Our Ref: FP/301/17/CLP
Your Ref:

Application for Lawful Development Certificate for a Proposed Use or Development

Development Lawful development certificate for a single storey side extension.
Location 74 Felpham Way Felpham

TITLE: EXISTING PLANS AND ELEVATIONS

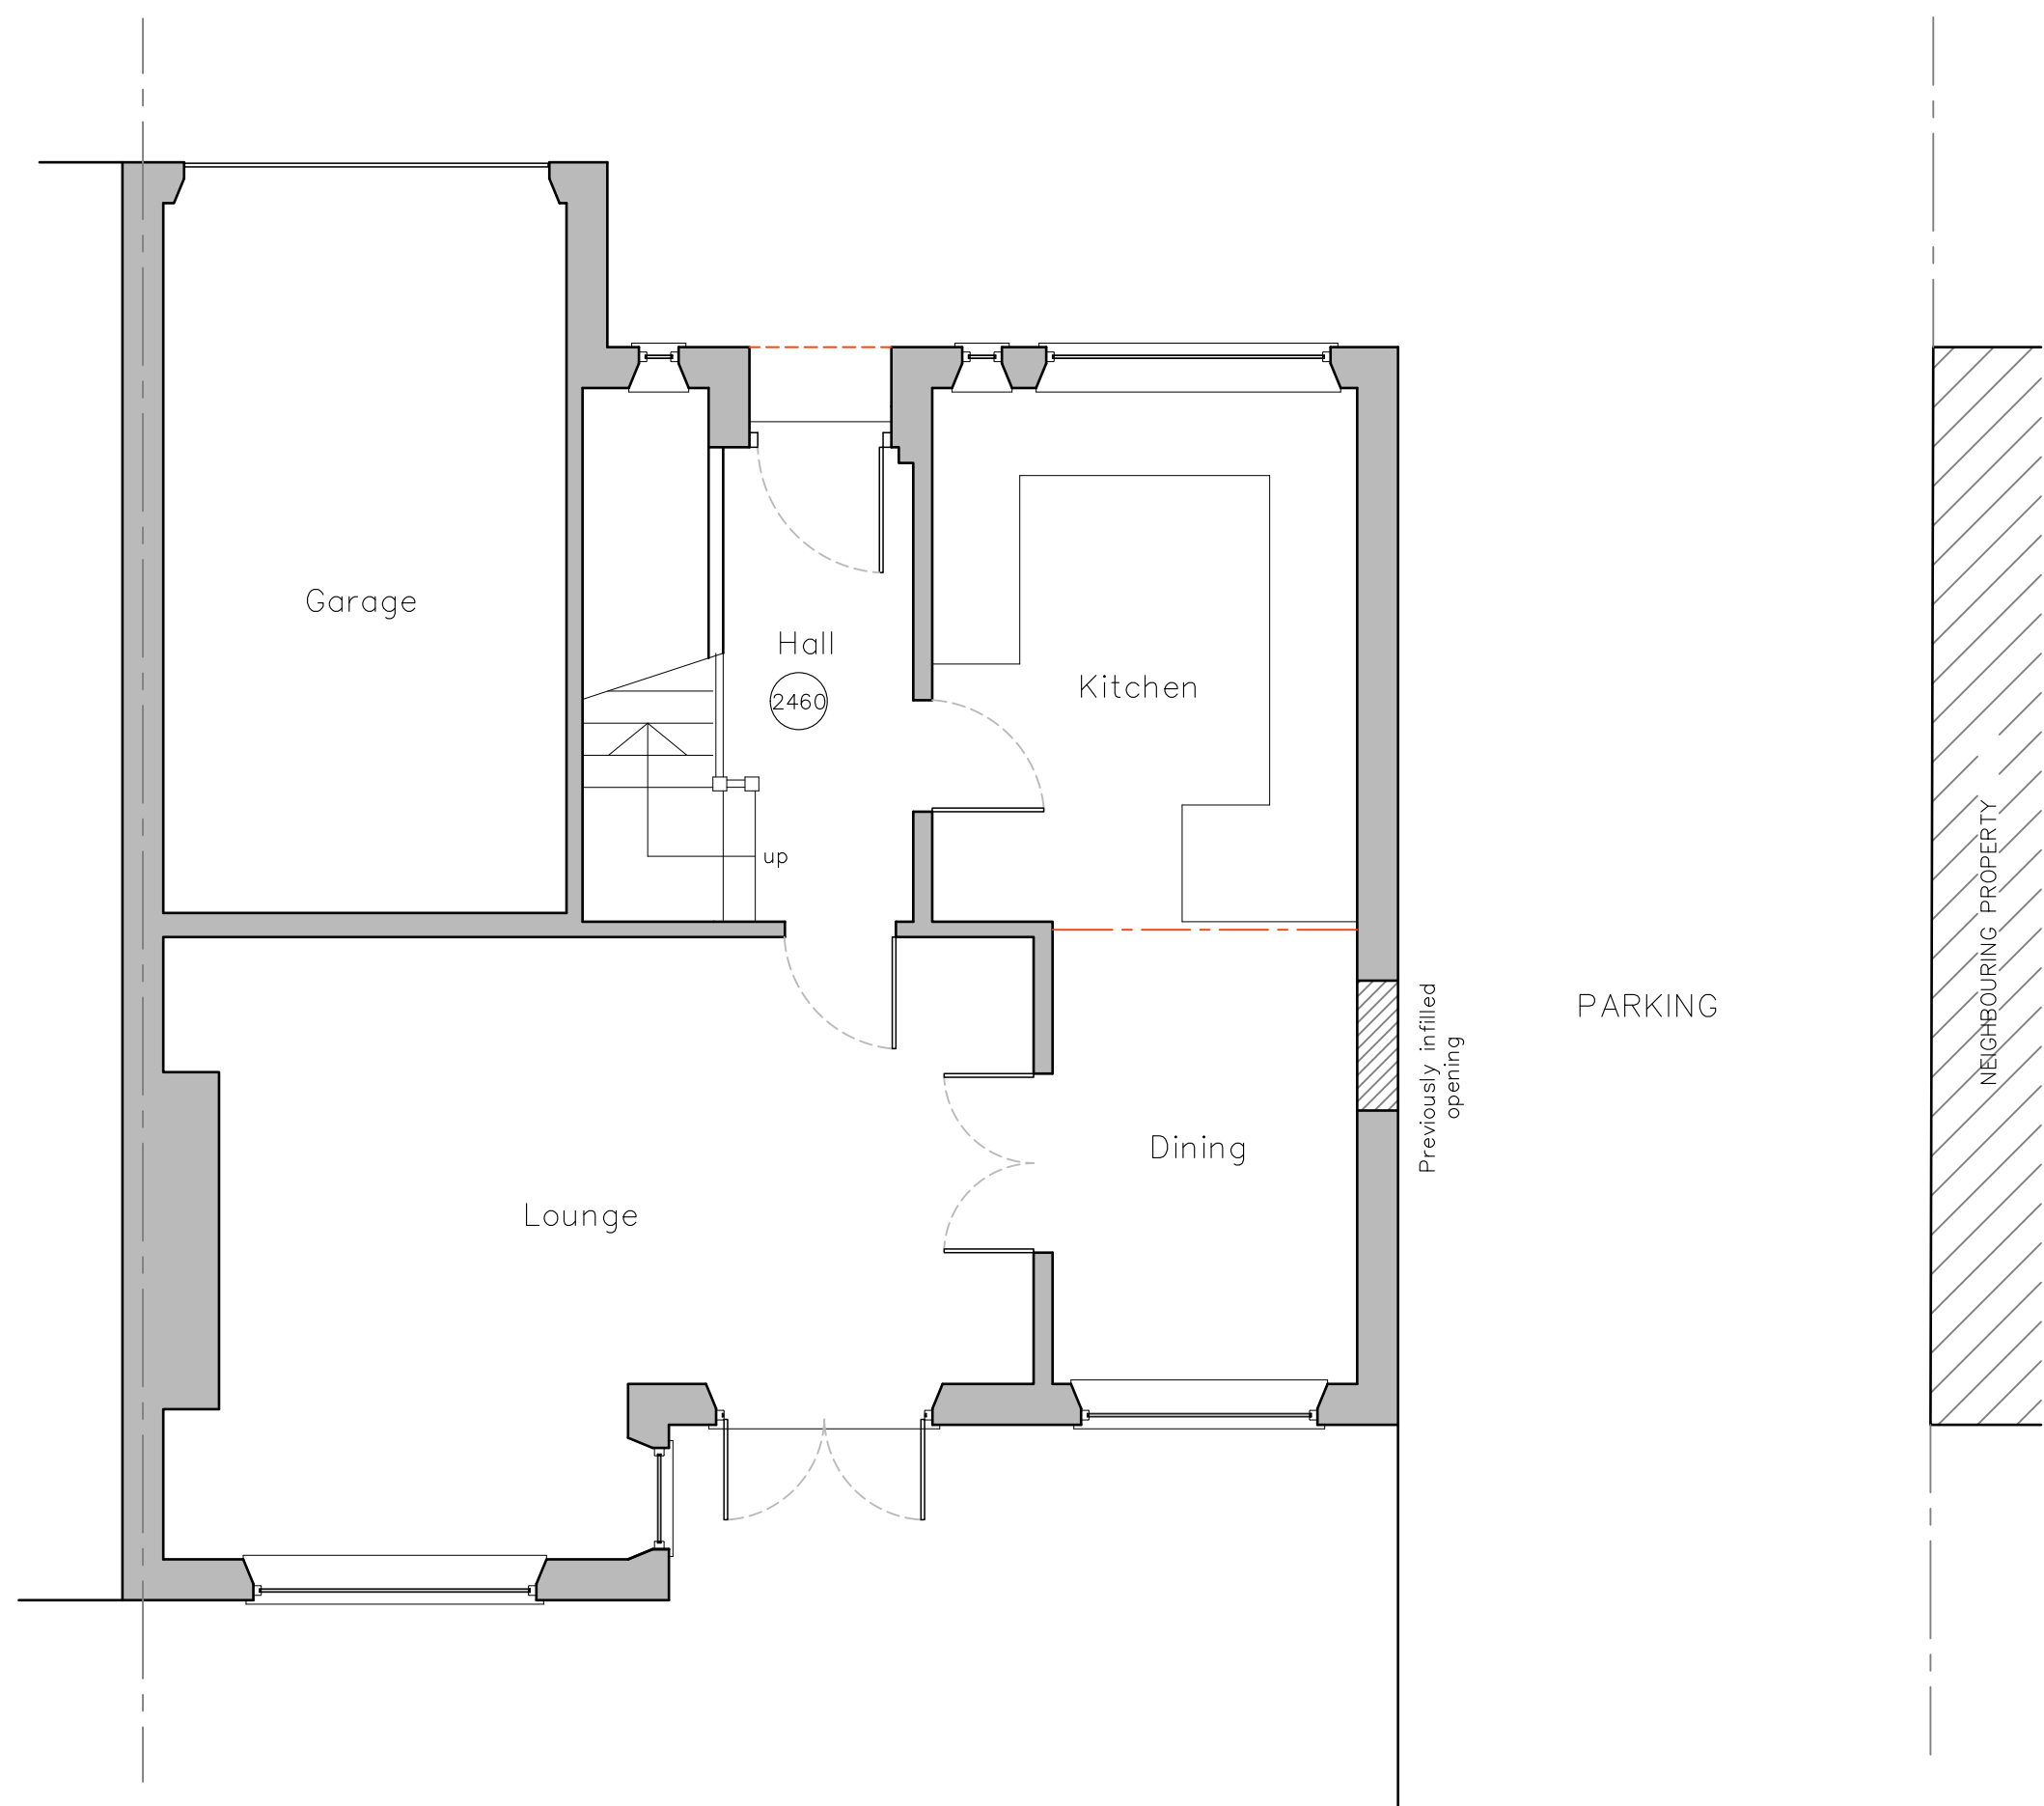
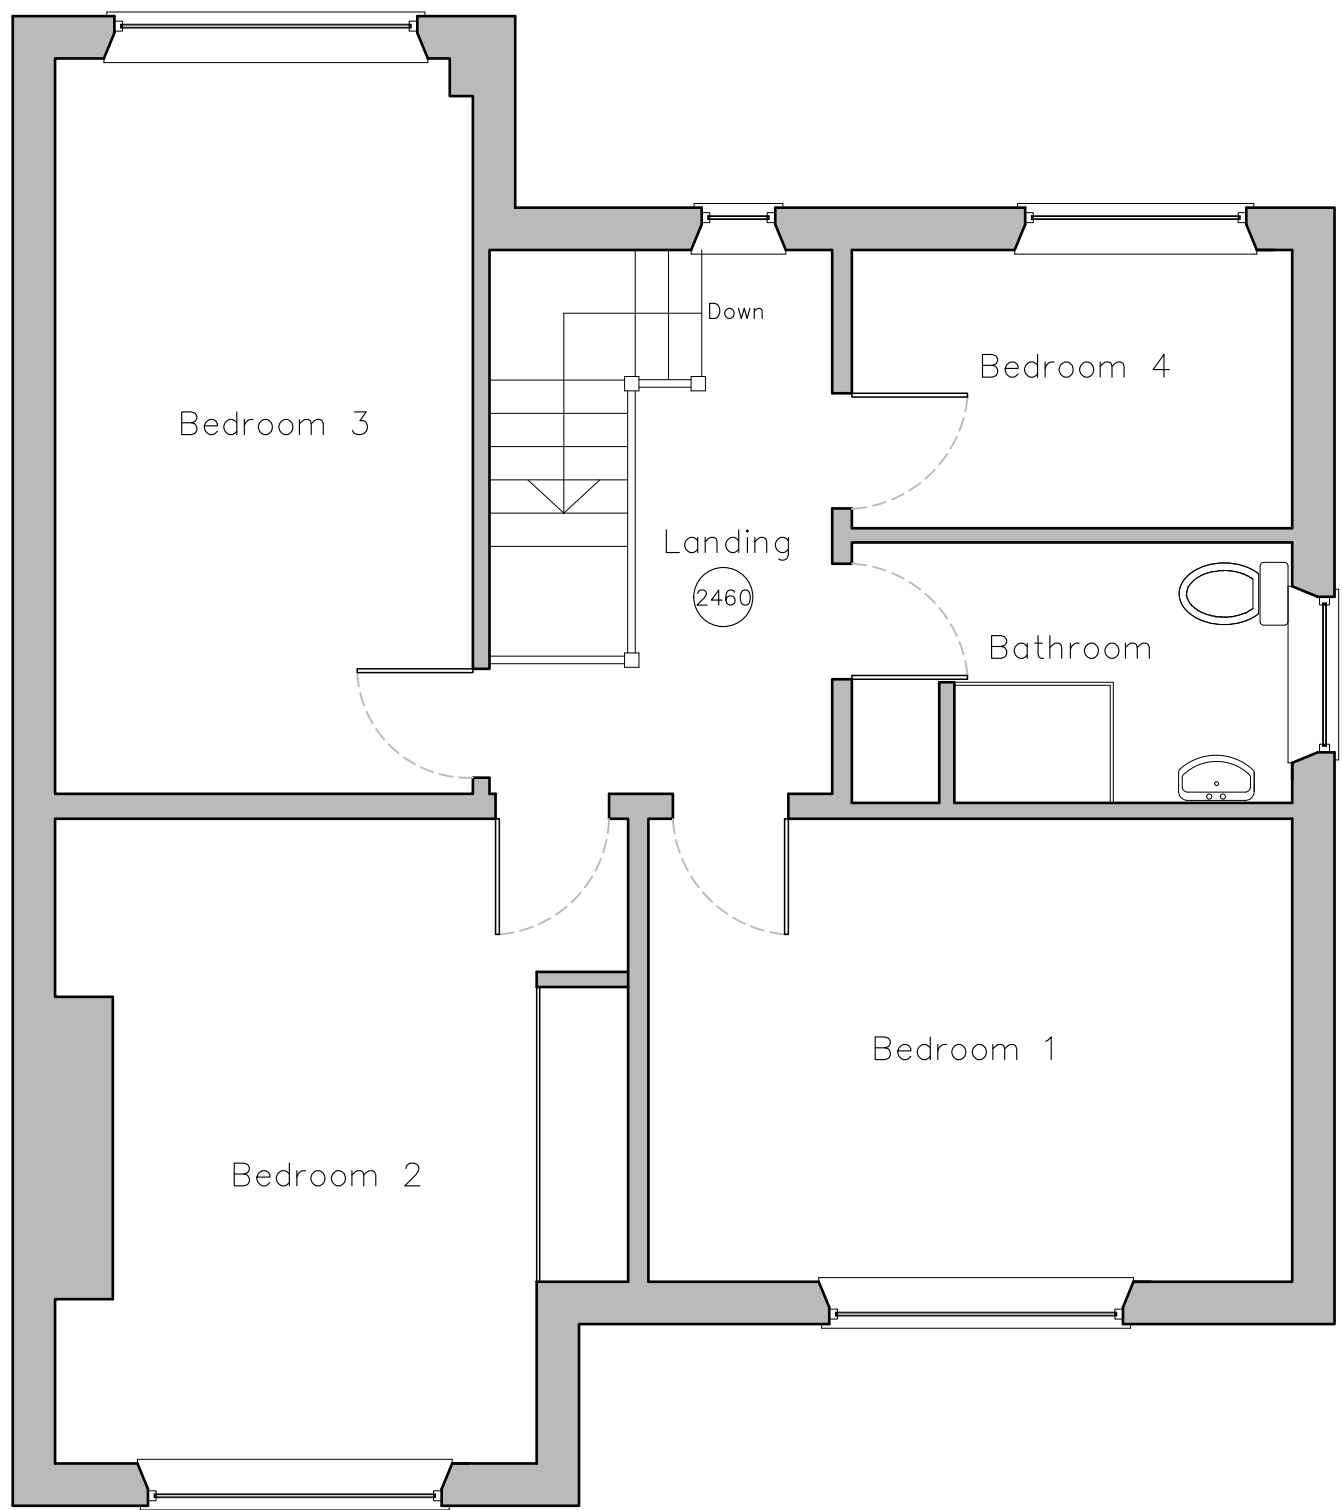
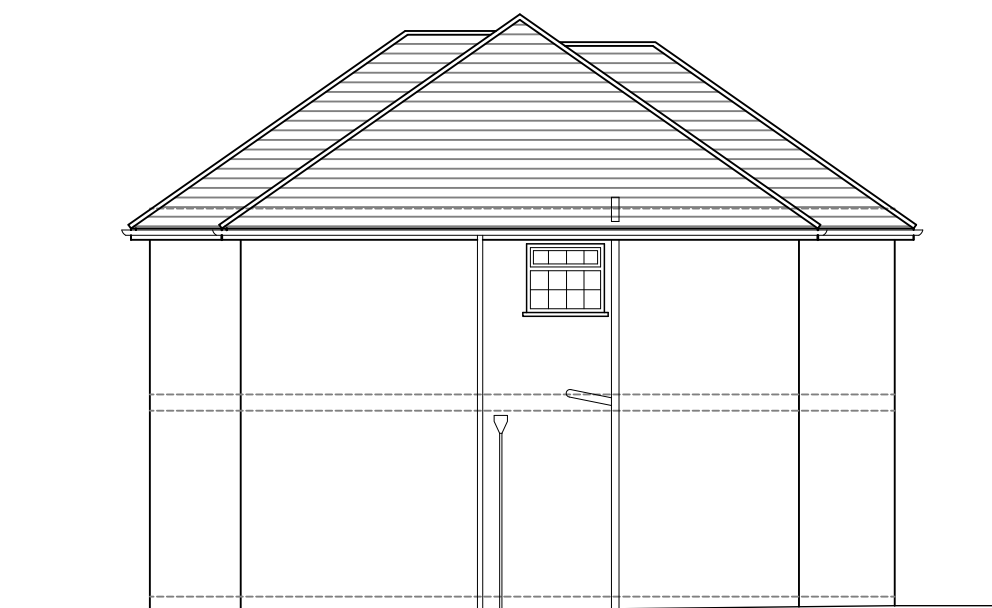
The existing elevations have been labelled as proposed. Please amend accordingly.
